2023/1099

Address: 3 Hild Avenue, Cudworth, Barnsley, S72 8RN

Description: First floor side and roof extension to 2 storey dwelling, including conversion of existing integral garage into habitable area.

| Rev | Description | By | Chk | App | Date |
|---|--------------------------------------|--|-----------------------------------|---------------------------------------|------|
| Drawing Title | | PROPOSED PLANS | | | |

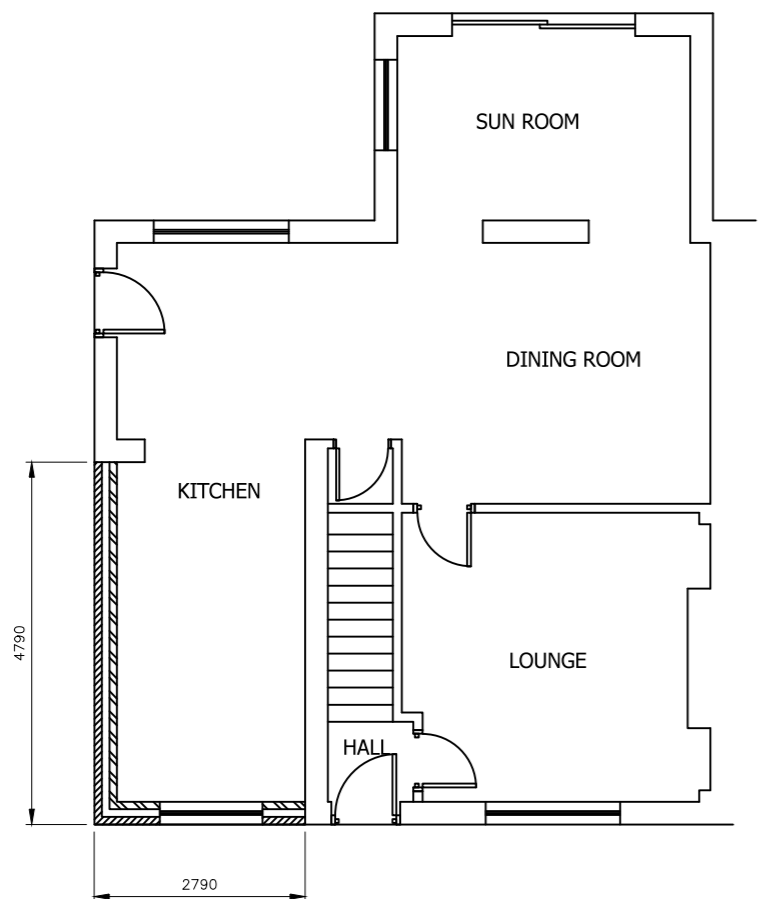
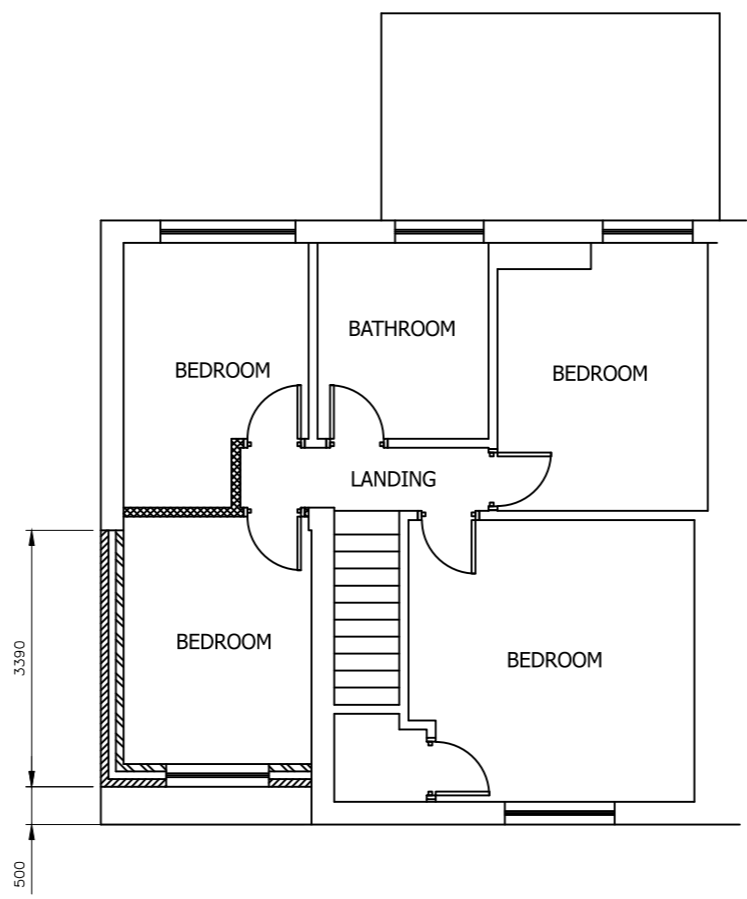
Whilst the garage would be lost, the plans indicate that provision for a second parking space at the front of the dwelling would be created. Following a request from Highways, further information was provided about access to the dwelling and subject to the proposal being constructed in accordance with the plans and subsequent (Highways) requested conditions, there would be no impact on Highway Safety.

Drawing Title **PROPOSED ELEVATIONS**

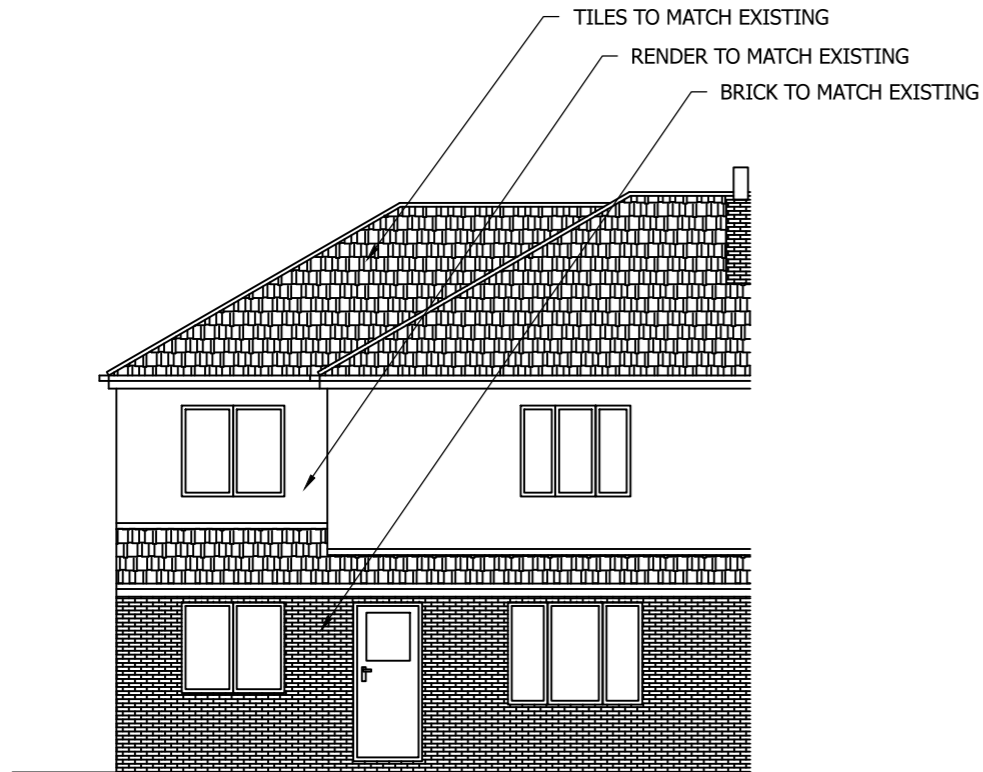
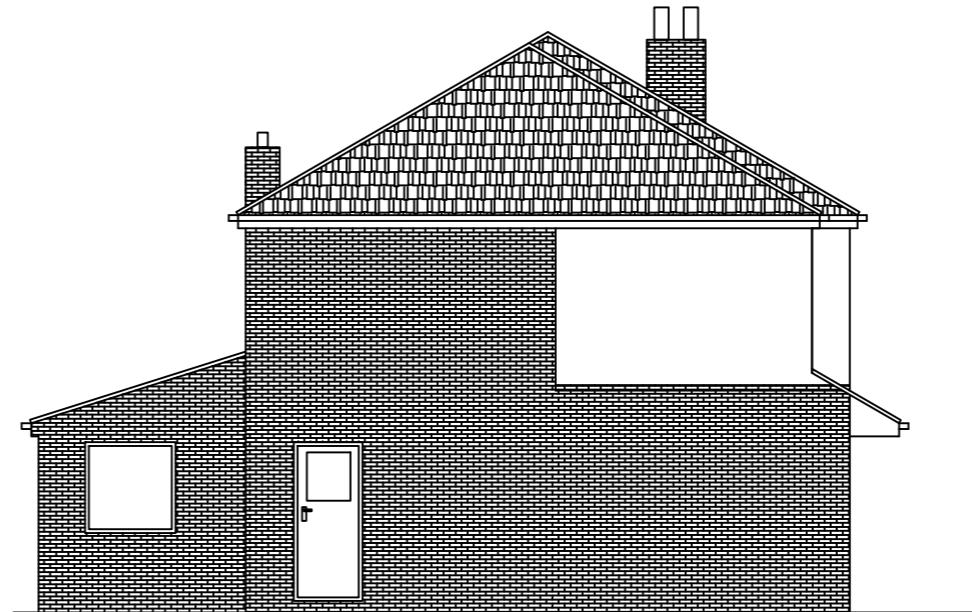
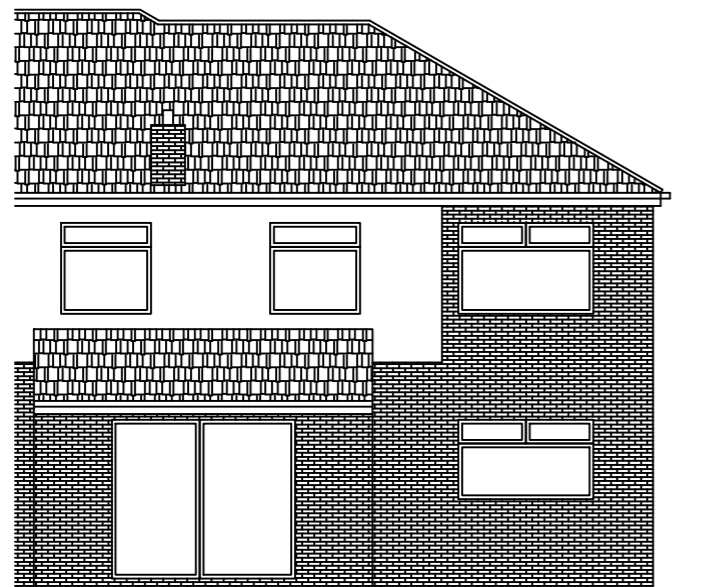
As the principal of an extension already exists, and with most of the side extension being two story already, the act of increasing the garage aspect to a similar level would have a minimal detrimental effect to the unattached neighbouring dwelling at No.5. Currently there is a 1.64m distance between the existing extension and the side boundary treatment, a low fence, with No.5. The distance between the actual extension and the side elevation of No.5 is 4.66m. On the side elevation of No.5 are an entrance door and three non-habitable rooms windows, these are a porch window and what is presumably a pantry window on the ground floor and a first-floor landing window. Despite the increased height of both the existing ground and first floors of the extension, due to a new pitched roof, as both dwellings face a north to northwest direction, the impact on sunlight would be minimal and only potentially affect a small portion of the front garden of No.5. With a 5m distance between the actual extension and side elevation, any sense of overbearing should be minimal, and with no side windows proposed, there would not be any issue in relation to loss of privacy for No.5.

In relation to the residential amenity of other dwellings on the street, there would be no noticeable impact, except possibly of the proposed bedroom window in the first-floor extension. The distance of the proposed window to the bedroom windows of the closest opposite dwellings at No. 4 & 6, would be circa 17m measured diagonally. The actual proposed window would not directly overlook any dwelling, but instead look directly into the front and side gardens of No. 4 & 6. Whilst the distance is approximately 12m from the extension to the curtilage of the opposite houses, this is the

Although the proposal would only increase the floorspace of the first floor by circa 9 sqm, the impact of the proposed roof would significantly alter the perceived size of the dwelling. Because of the design of the proposed roof, which would be of a good design match to the original roof, and equally show subservience, as would the setback of the proposed ground and first floors, overall, the structure of the extension would potentially be a visual improvement of the current dwelling, or at worst have a neutral improvement on the already poorly implemented flat roofed extension. As the chimney loss is not that of the original chimney, its loss would be insignificant. Again, with the removal of the garage door and replacement with a window, this would be both insignificant and at worse have a neutral impact on the character of the dwelling or visual amenity of the area.
